**KIRKLEES METROPOLITAN COUNCIL
INVESTMENT & REGENERATION SERVICE**

**DELEGATED DECISION FOR APPLICATION FOR CERTIFICATE OF
LAWFUL DEVELOPMENT**

Reference no.: 2023/CL/92925/E

Description: Certificate of lawfulness for proposed single storey
side extension and garage conversion with associated alterations

m ward architectural drawing services
 94 Ferrybridge Road, Castleford, West Yorks, WF10 4JR
 tel. 01977 513891 e mail mwardarchitect@aol.com
 Plans as proposed at 33
 Greenfield Crescent,
 Grangemoor, WF4 4WA for Mr &
 Mrs Mark Sergeant.
 date SEP 2023 scales 1:50 1:100 (@ A1) dwg. no. 3051.02

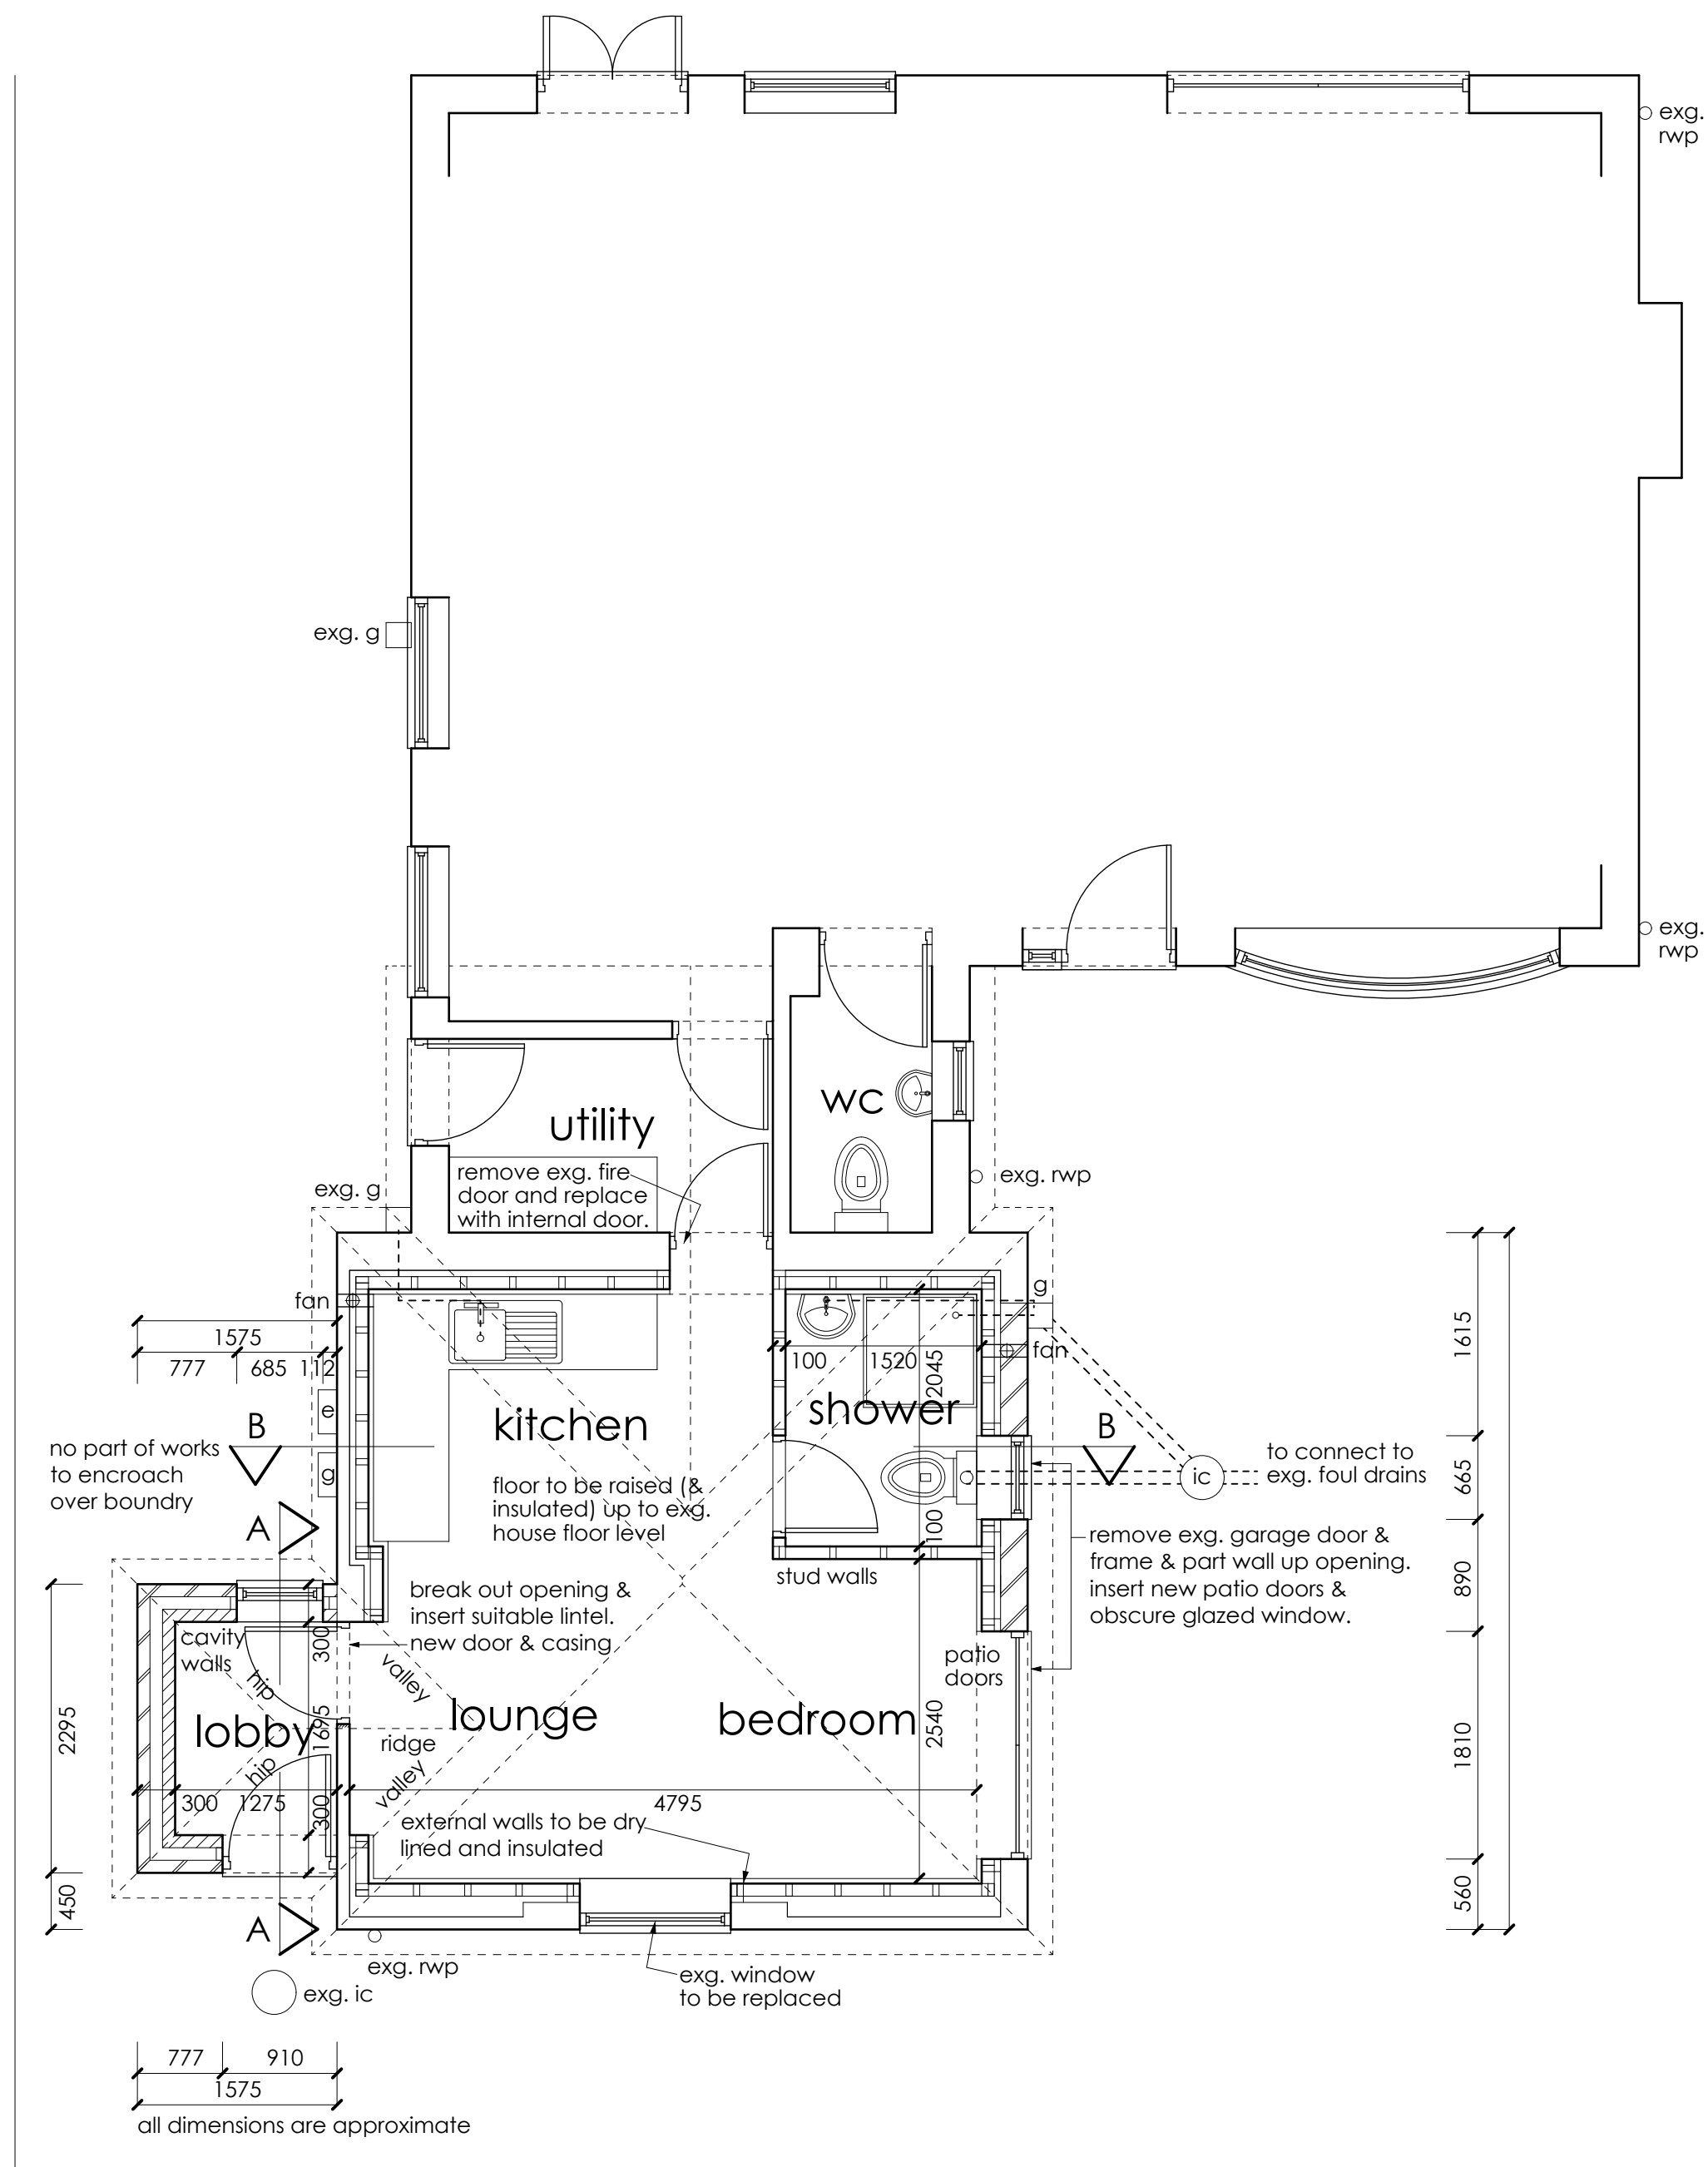
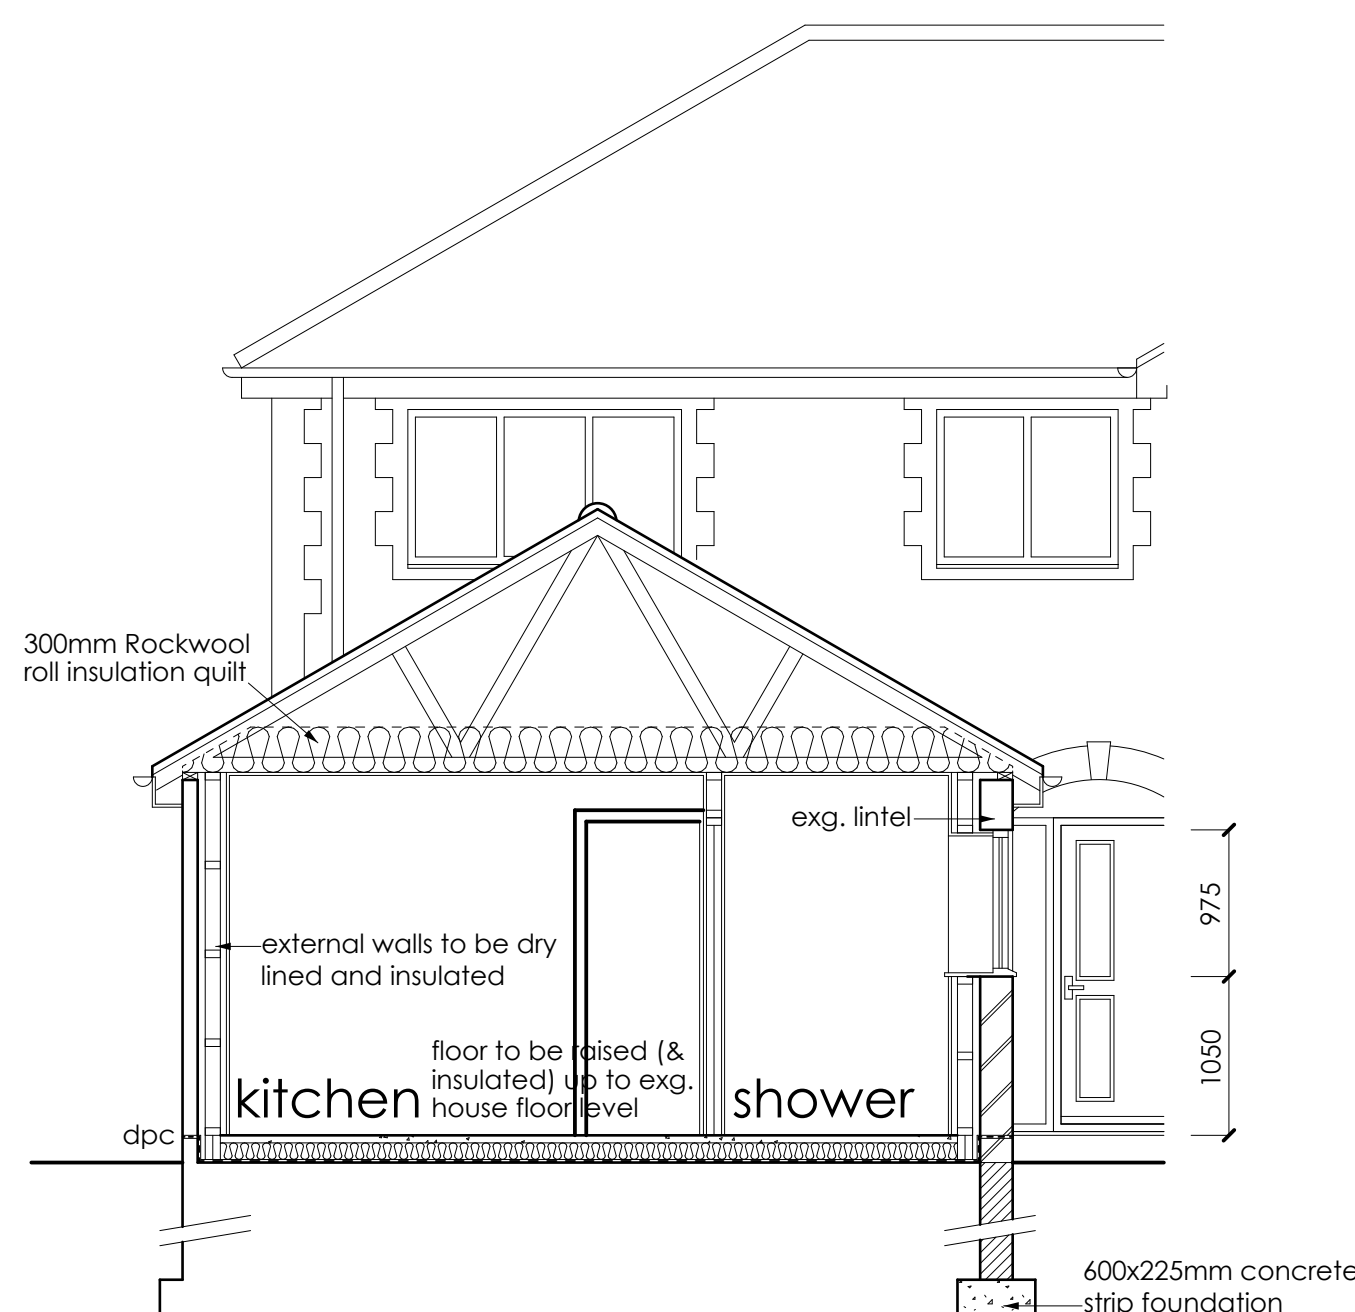
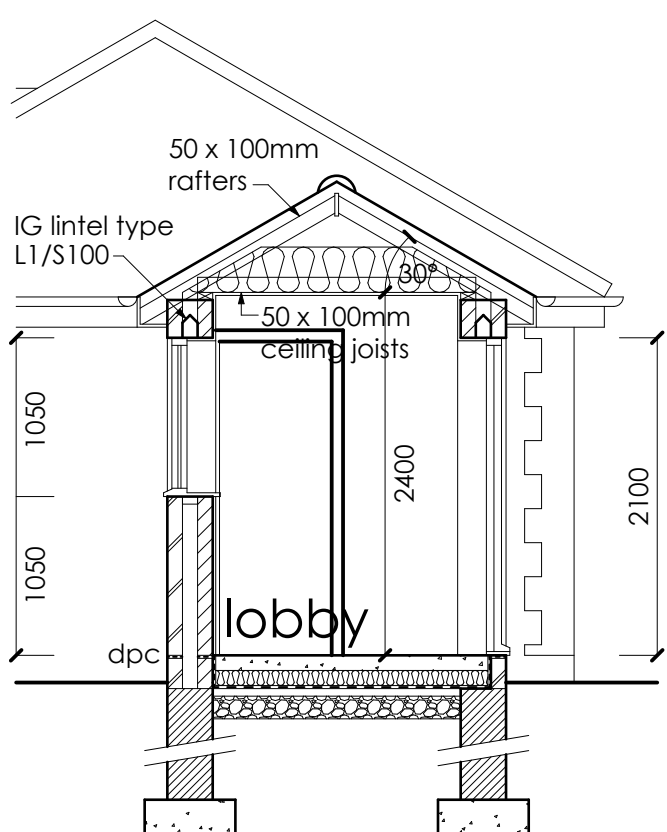
The extension would project from the side elevation of the property by 1.5 metres and would be a total width of 2.3 metres with an eaves height of 2.4 metres rising to an overall height of 3.4 metres to the ridge of the roof.

Comment: *The enlarged part of the dwellinghouse is within 2 metres of the boundary of the curtilage of the dwellinghouse, and the height of the eaves of*

the enlarged part is proposed to be 2.5 metres, therefore shall not exceed 3 metres

Comment: *The enlarged part of the dwellinghouse would extend beyond a wall forming a side elevation of the original dwellinghouse but would not exceed 4 metres in height; is to be single storey in height; and shall not have a width greater than half the width of the original dwellinghouse.*
